**Stage 1 State Significant Development Application (SSDA) for 201-217 Elizabeth Street,
Sydney NSW 2000 (D/2017/349, SSD 8105)**

Thank you for your letter dated 28 March 2017, requesting Transport for NSW (TfNSW) review and comment on the above.

NOT FOR CONSTRUCTION
SYDNEY METRO CITY & SOUTHWEST
PITT STREET STATION
201-217 ELIZABETH ST. CAR PARK RAMP PROXIMITY

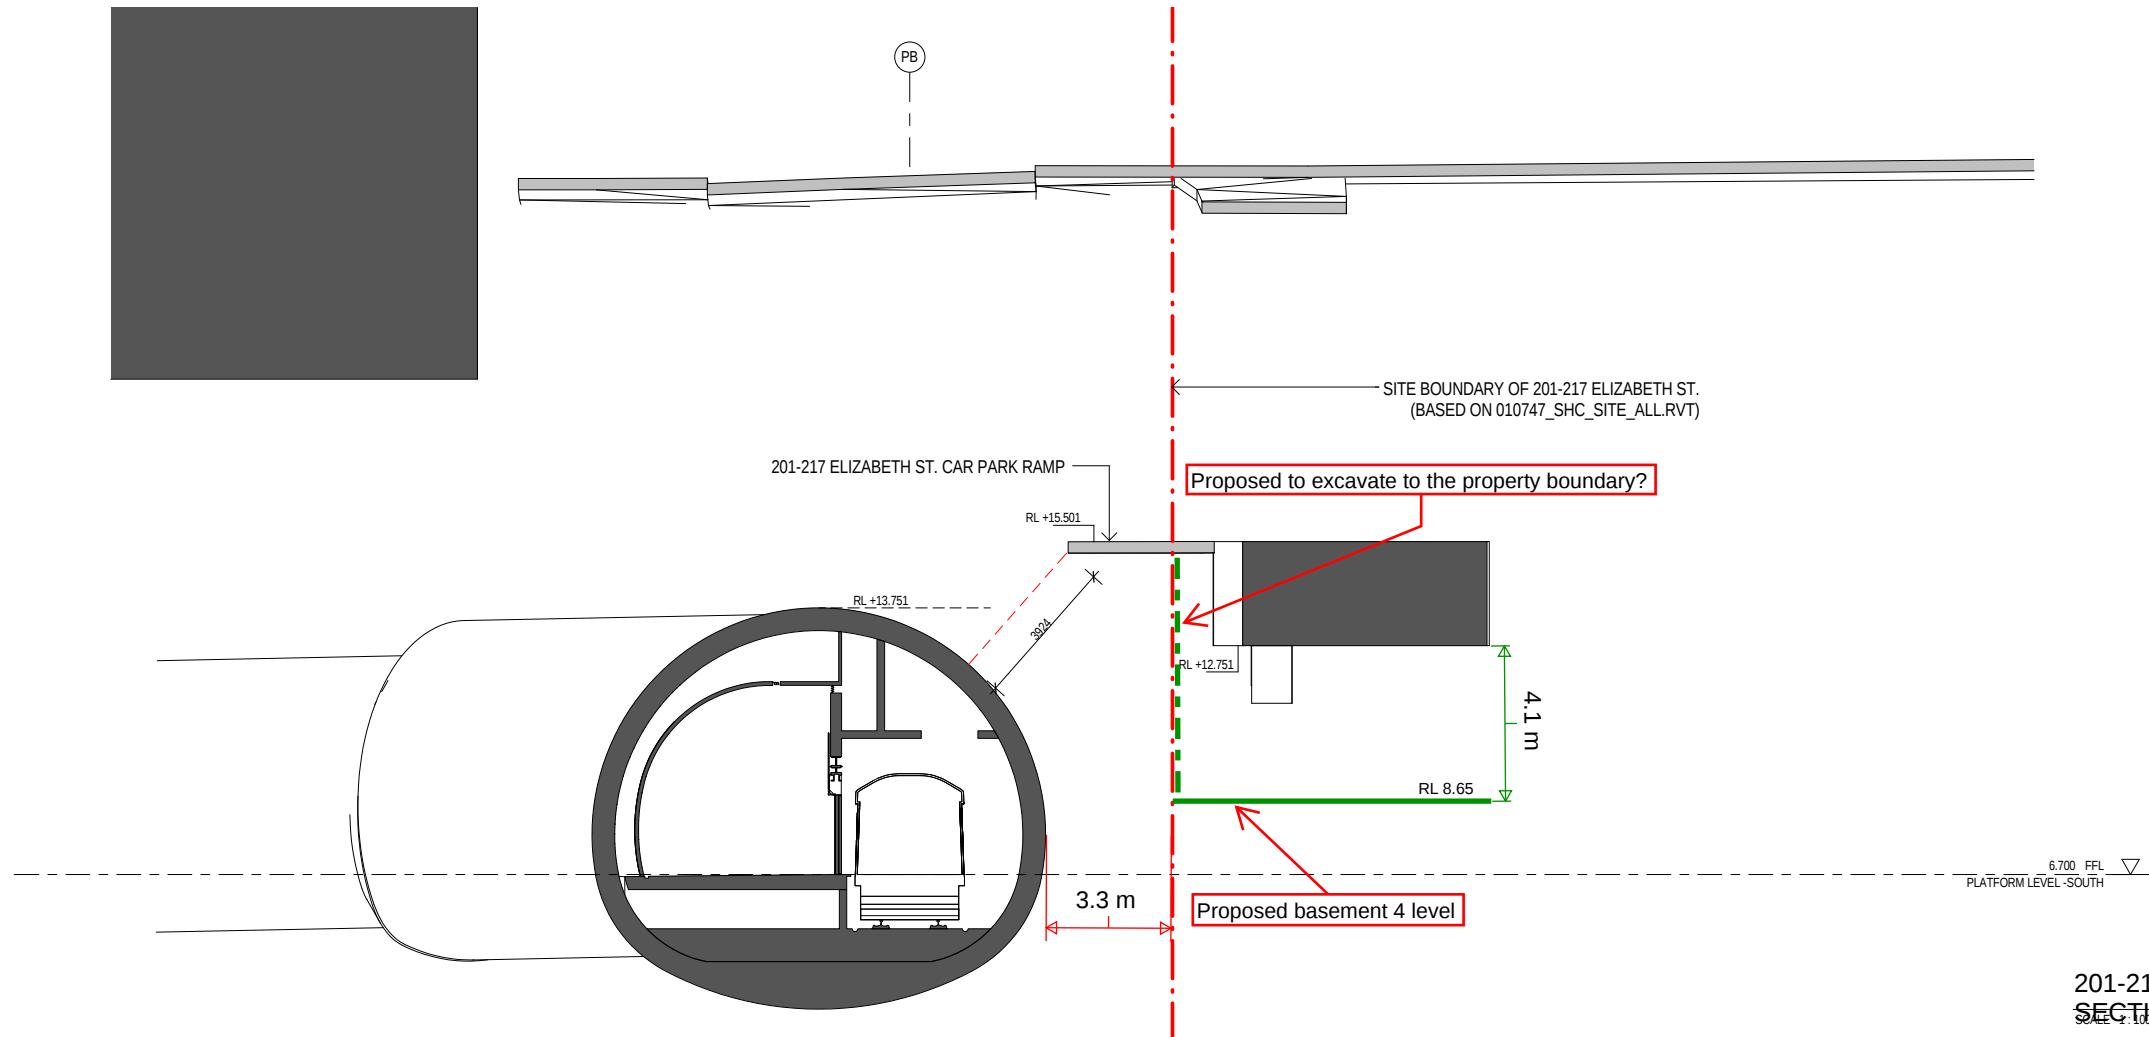
- There are significant concerns that the proposed development would have an adverse effect on the viability of Sydney Metro City and Southwest;
- The demolition of the existing building will release the existing building load and induce field stress re-distribution. This procedure may also have adverse impacts on the Metro Station structure and should be addressed prior to demolition; and
- The placing of any foundations, other structures and building loads in or near the proposed Sydney Metro alignment may affect the practicability of constructing the Sydney Metro City and Southwest tunnels.

2. Prior to the Stage 2 Development Application lodgement over the subject site the developer is to consult with TfNSW to review the basement levels proposed in the concept scheme to assess the vertical separation to the Sydney Metro City and Southwest tunnel including the potential foundation arrangement (depth and loads).

3. Prior to the Stage 2 Development Application lodgement over the subject site the developer is to consult with TfNSW to review the demolition of the existing building and proposed excavation of the site to ensure that the unloading and movement of rock and potential impacts on temporary and permanent rock support in the Metro cavern are assessed and managed to avoid any adverse impacts.

- (h) the design and construction of the basement levels, foundations and ground anchors for the approved development are to be completed to the satisfaction of TfNSW. The developer shall develop their foundation design to ensure that all loads are transferred down to the 2nd reserve, i.e. pile founding level below the tunnel invert, pile to be sleeved through the 2nd reserve etc. Cross sectional drawings showing the proposed basement excavation and structural design of sub ground support adjacent to the rail corridor should be included for the proposed foundations.
